LIBERTY TREE ACADEMY
CONSTRUCTION DOCUMENTS
TOWN OF PEYTON, EL PASO COUNTY
PRELIMINARY DESIGN
MAY 2018

LIBERTY TREE ACADEMY

TOWN OF PEYTON, EL PASO COUNTY
CONSTRUCTION DOCUMENTS

| DESIGNED BY: ACR | SCALE: HORIZ AS SHOWN | DATE ISSUED: AUGUST 2018 | DRAWING No. SD01 |

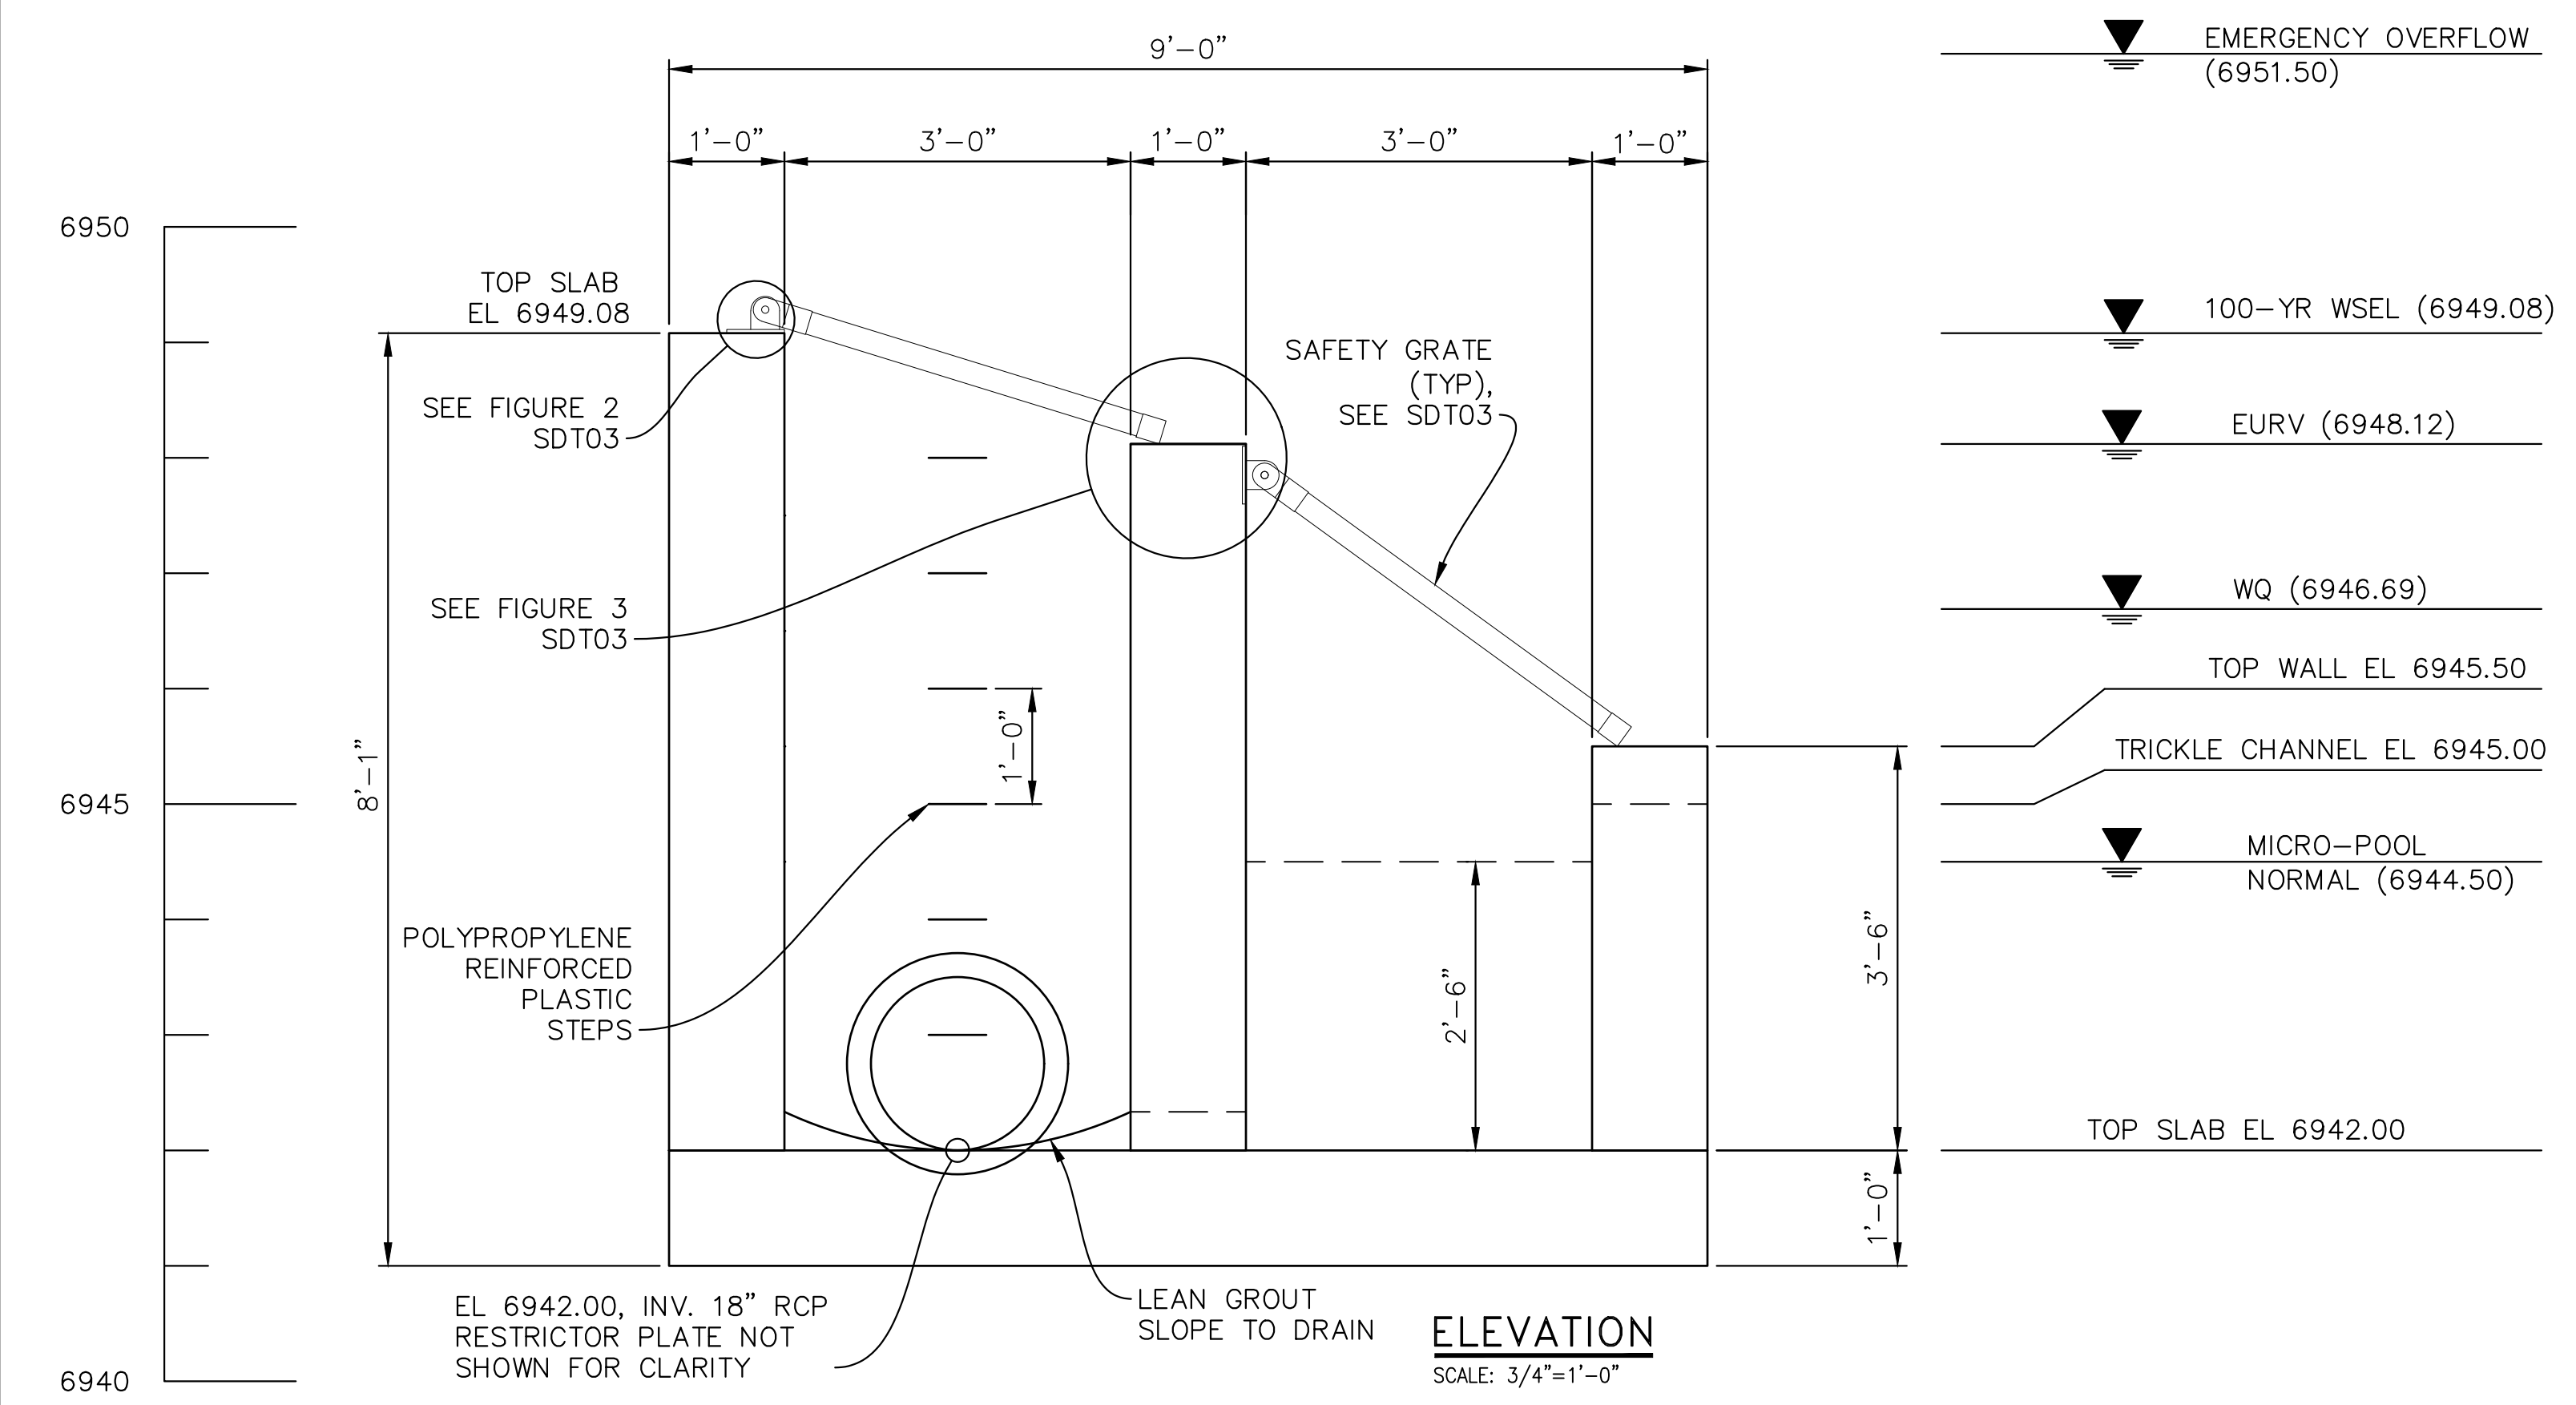
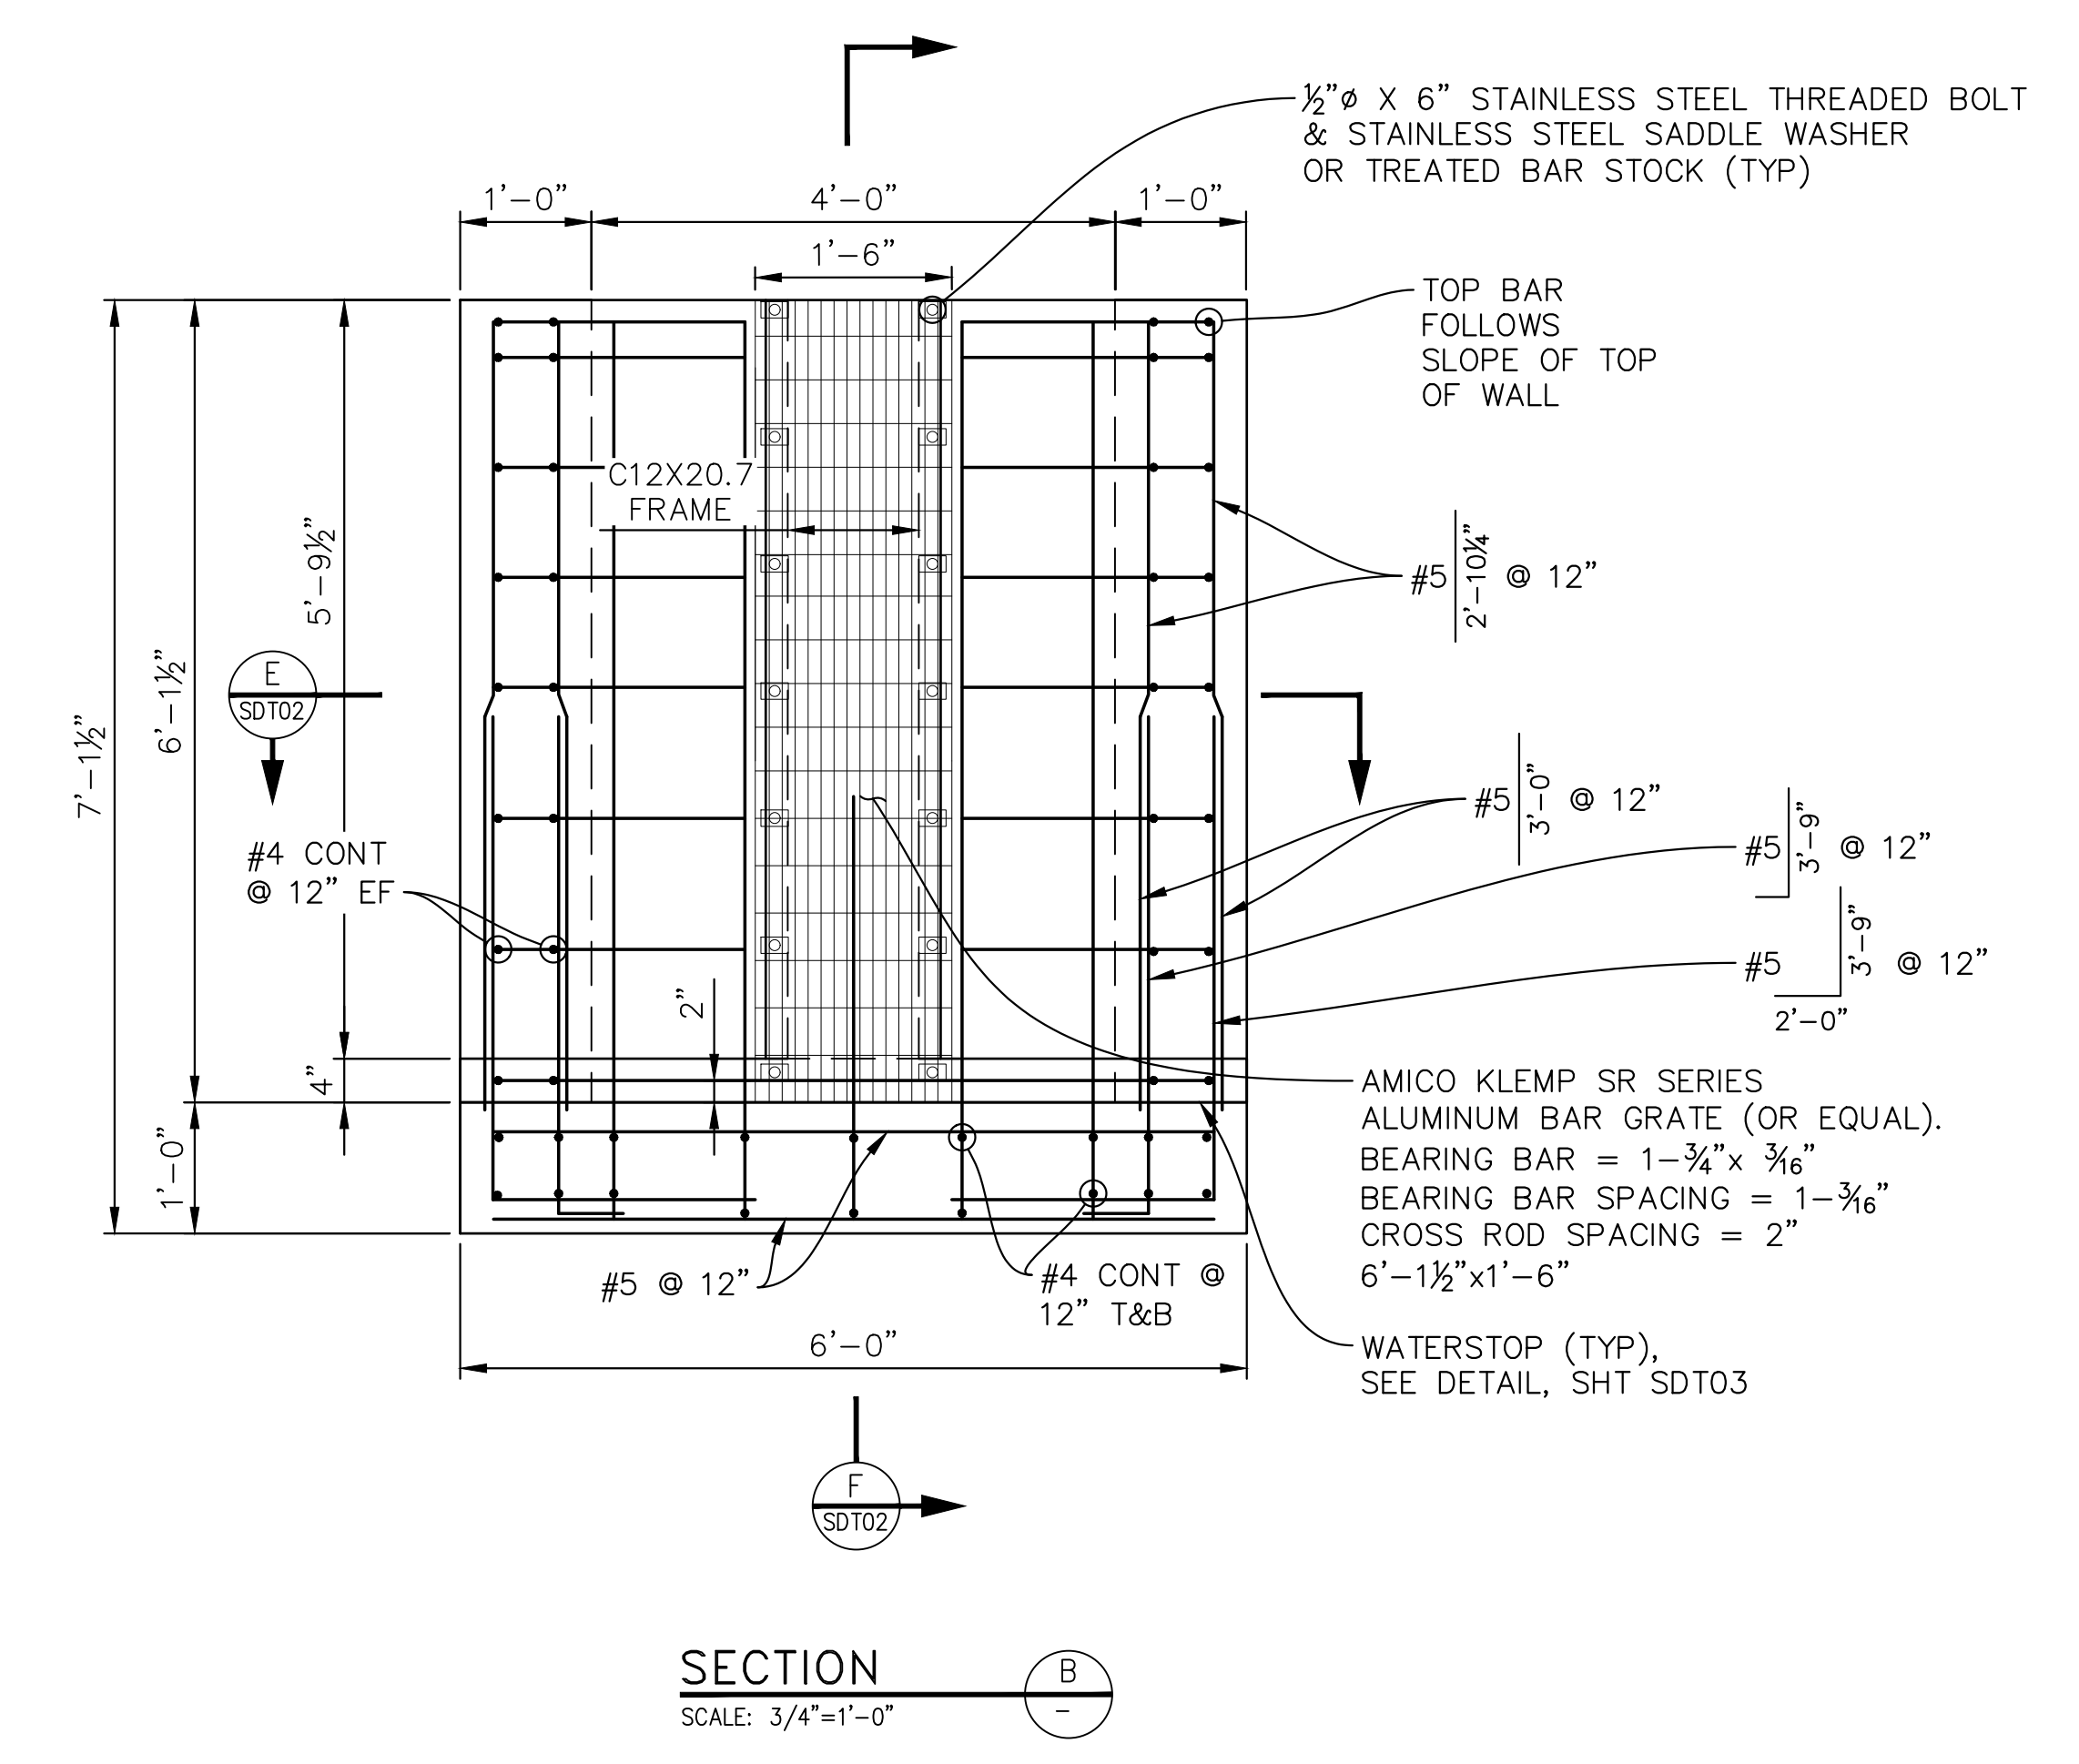
Pipe doesn't match. Address outfall protection.
RESPONSE:
PIPE UPDATED & PROTECTION ADDRESSED
